Read
Burnley

13 January 2021

Re: Planning Application No. 3/2021/0011

sheet: os plan

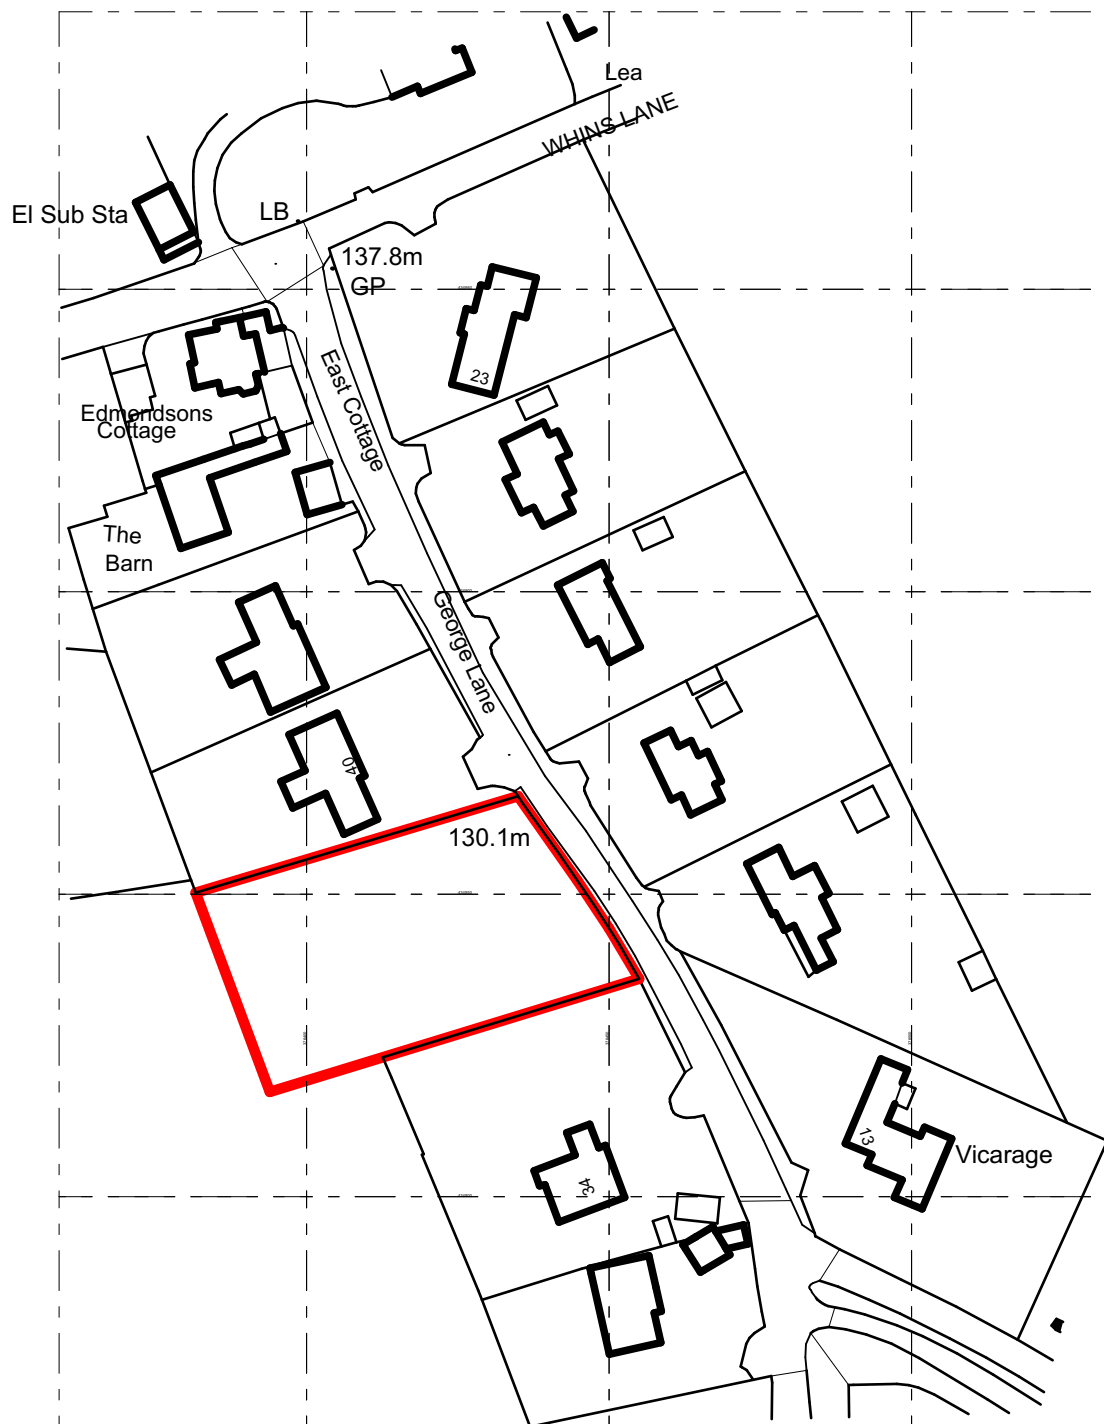
1. Incorrect data on location maps – We again draw your attention to this matter as highlighted in my previous letter relating to outline planning permission on the 22 October 2019. The planning application submission is incorrect and uses out-of-date information. The location plan shows our property in the adjacent plot as it was, as a smaller dwelling, prior to extensive renovations and extension almost doubling the size of the property and taking it closer to the proposed development and boundary line following planning permission approval in late 2016. We do not believe the drawings show the proximity and scale of our property in relation to the proposed new development and would be concerned how a committee would be able to assess the impact on surrounding properties without this clearly shown. We suggest plans are resubmitted with the correct current information.

sheet: proposed plans and elevations

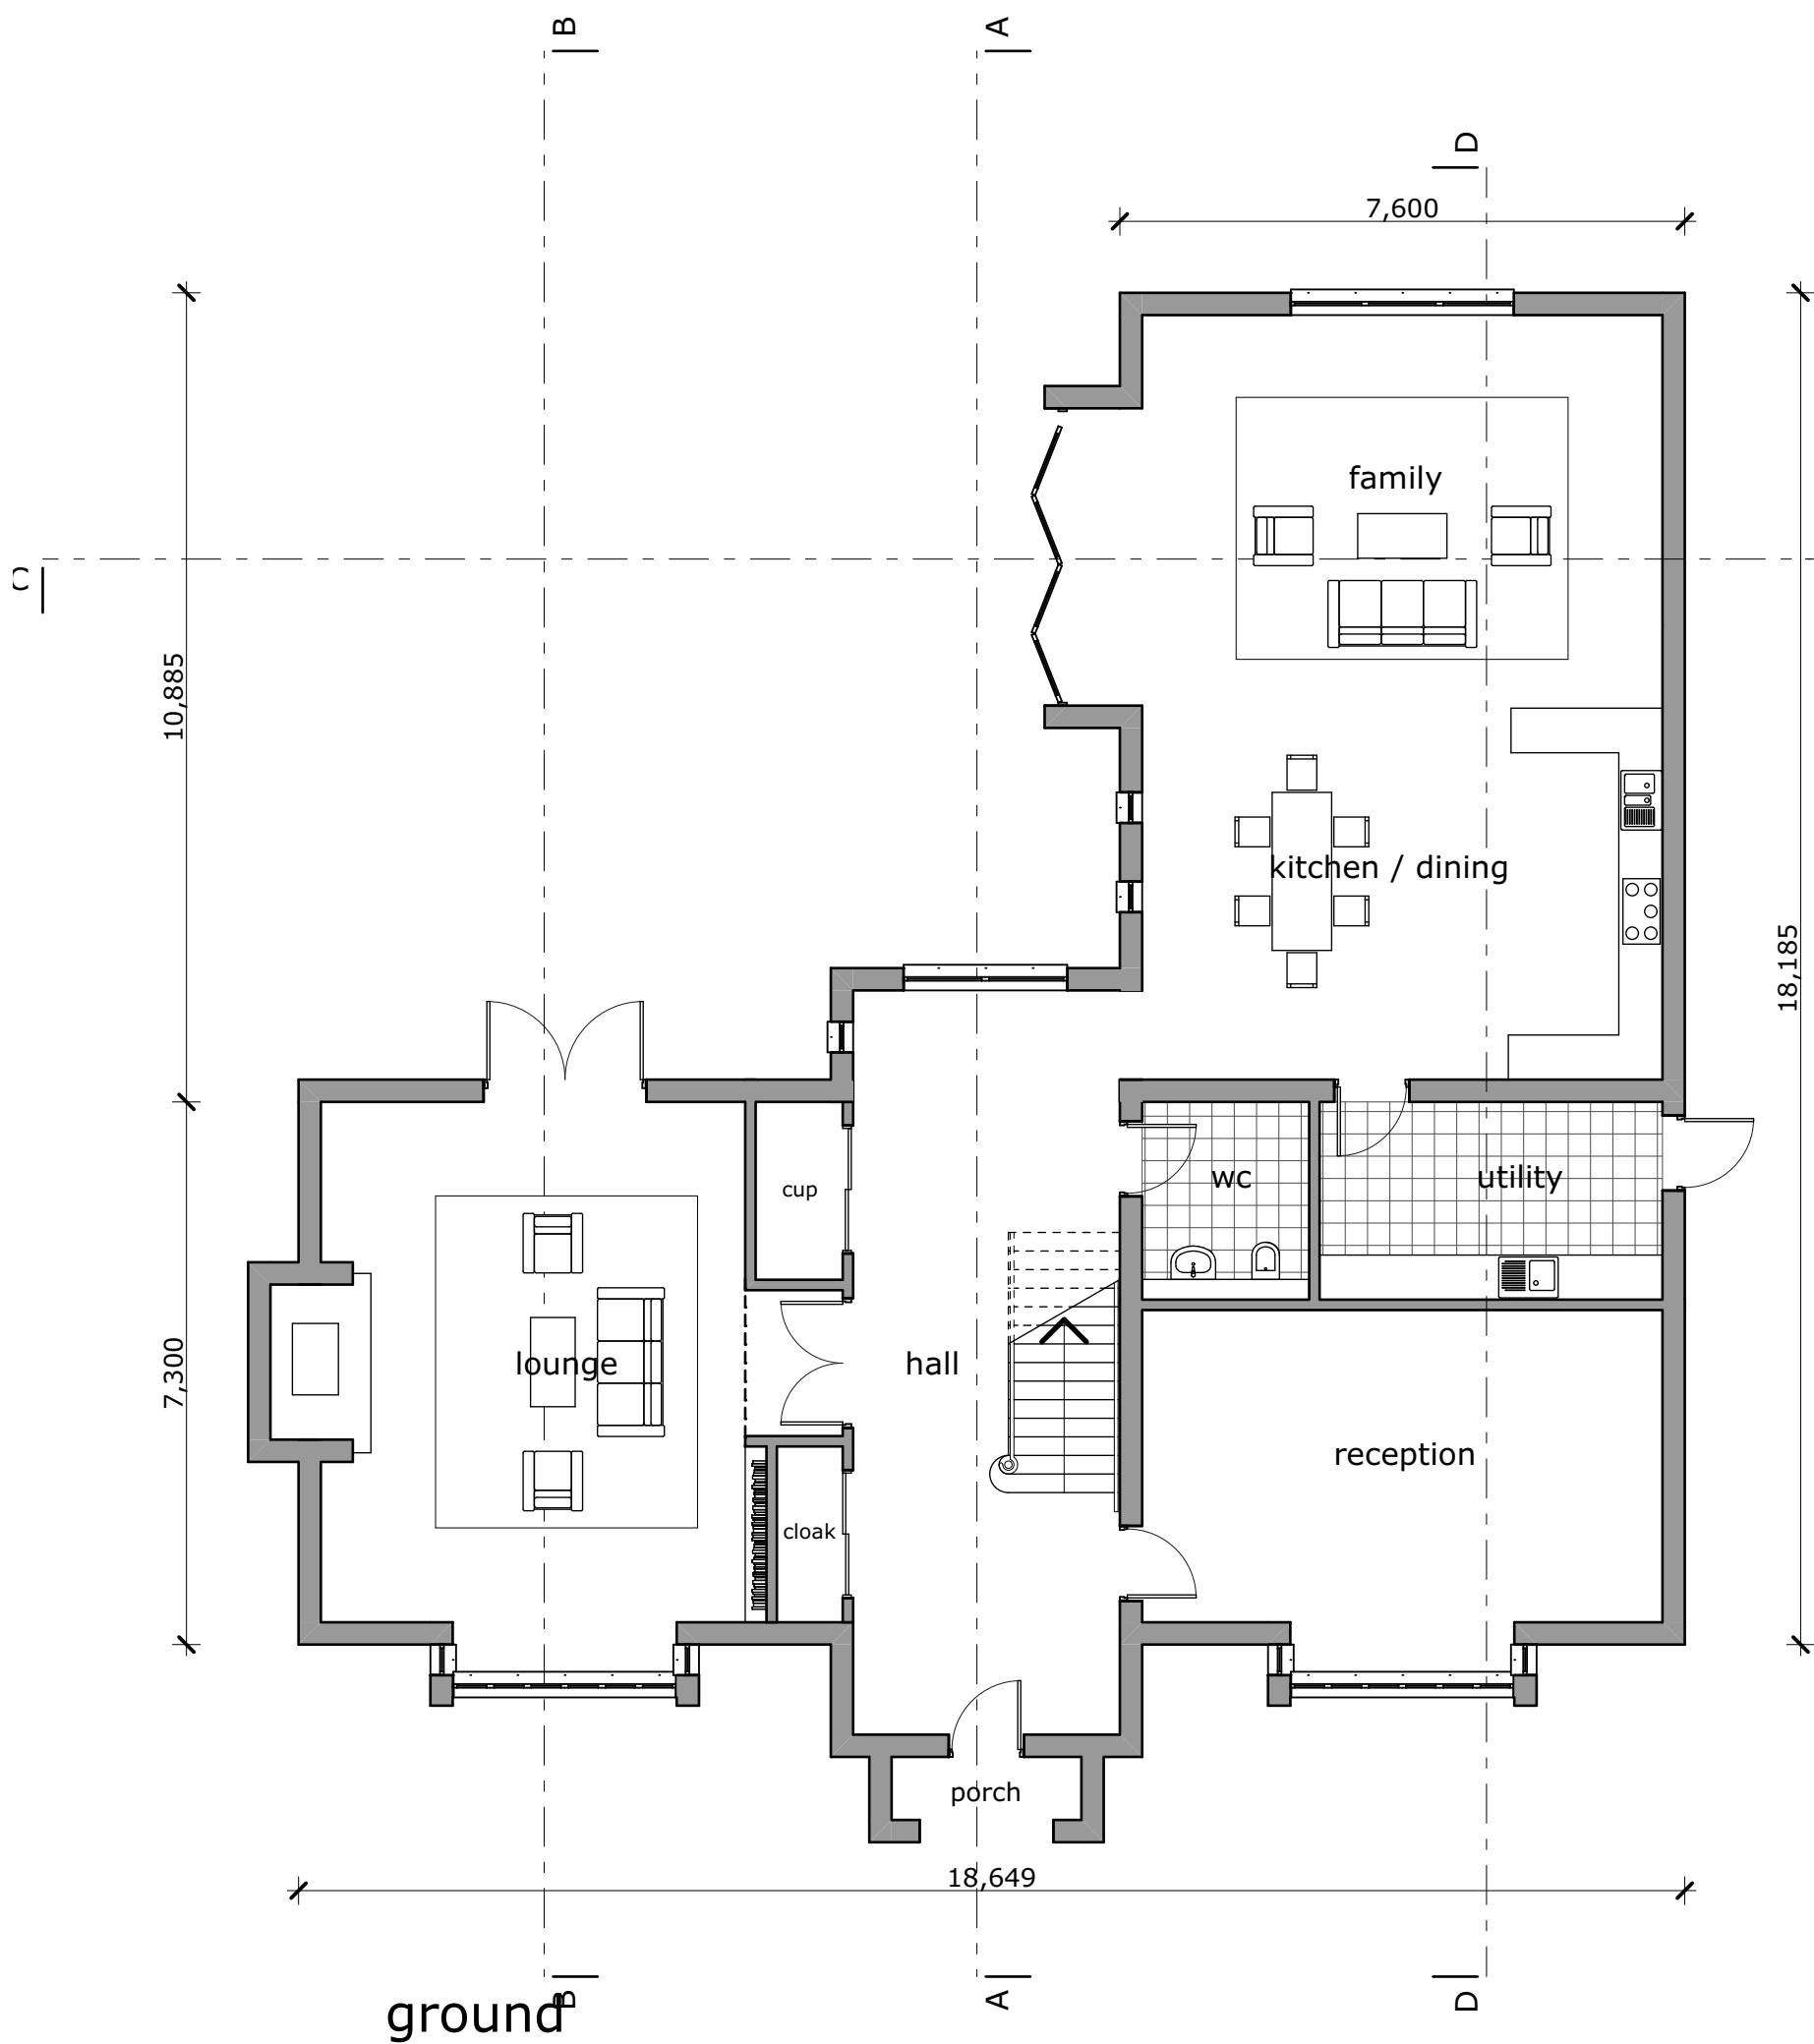
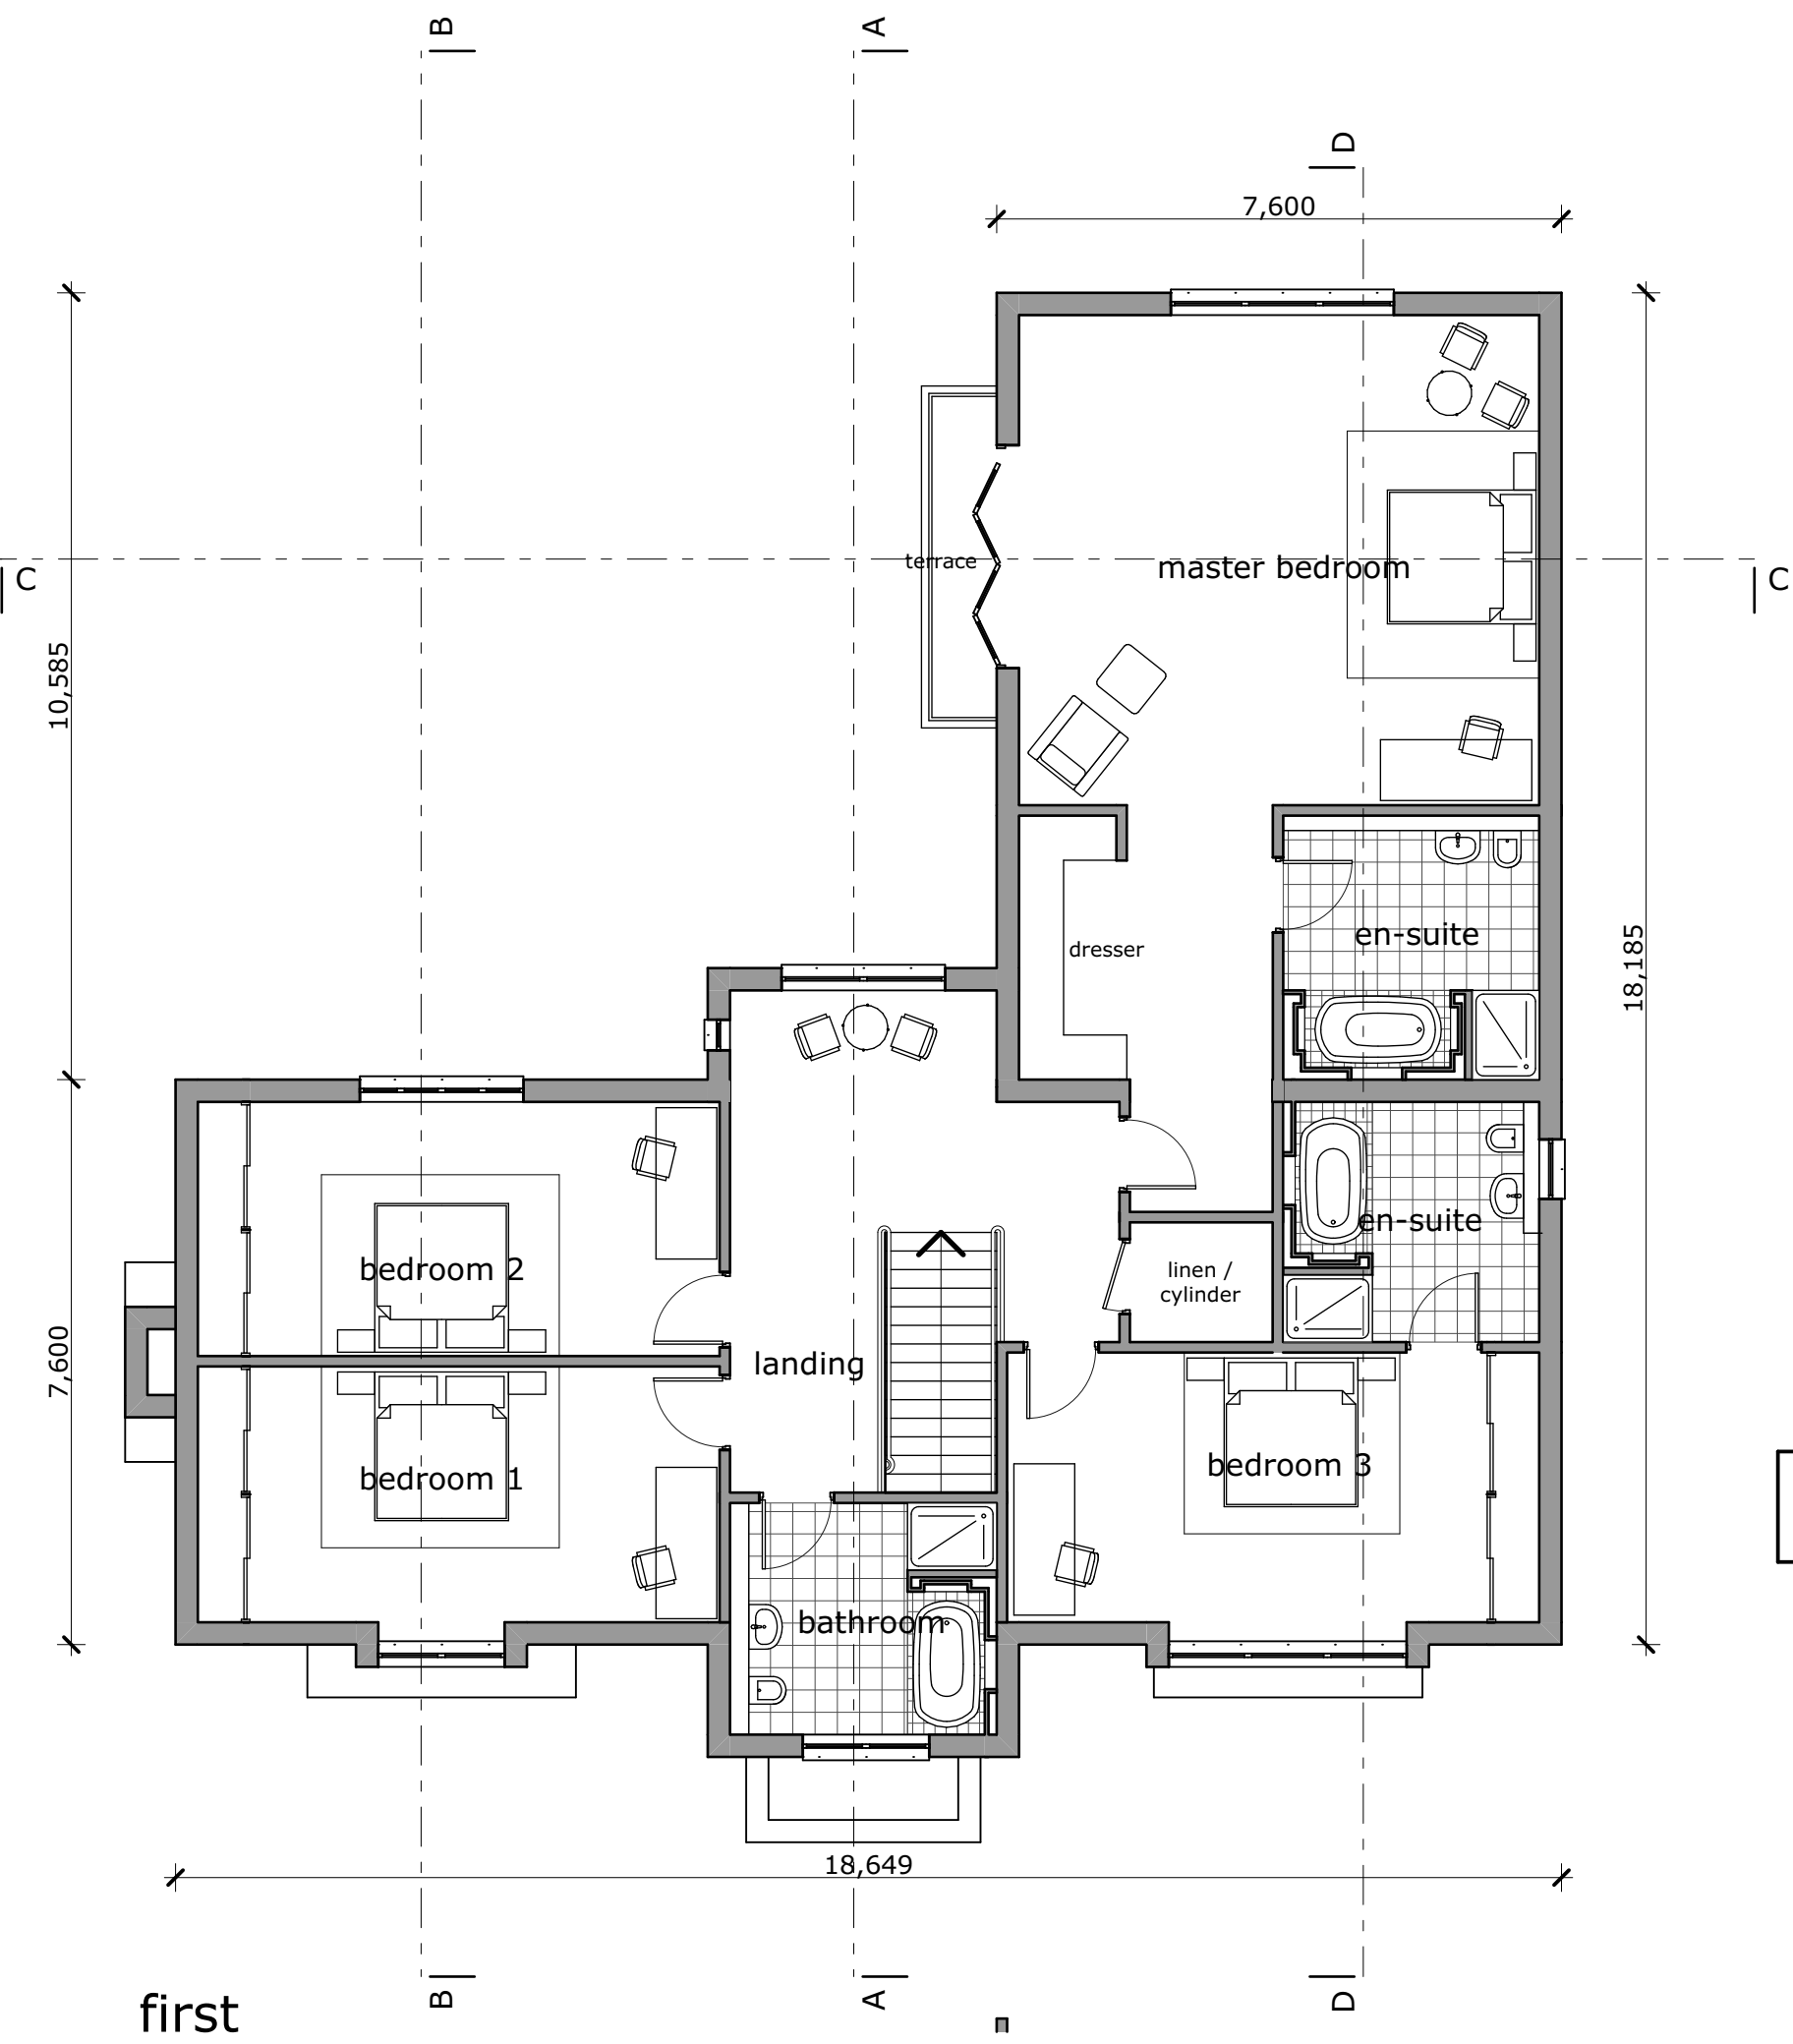
3. Overlooking and loss of privacy – the proposed development is at a higher elevation than our property which in winter, when the trees lose their leaves, offers a direct vantage point into our garden, main reception room and master bedroom windows. We had presumed any windows adjacent to our property would be limited, or frosted for privacy if development took place?

4. Balcony – A stipulation of our own relatively recent planning consent when we extended our property and created a balcony which overlooks our neighbour's garden, in a much less intrusive fashion, was to screen visibility with opaque glass. While we recognise each planning application is considered on its merits we would be looking for some consistency in the planning departments decision making. As this particular solution doesn't appear possible with the current proposed balcony positioning, we would suggest that the proposed balcony in the master bedroom face directly into Hammond Ground through the other window rather than the side facing adjacent buildings and gardens with opaque glass being used on the side panels to provide us with adequate privacy.
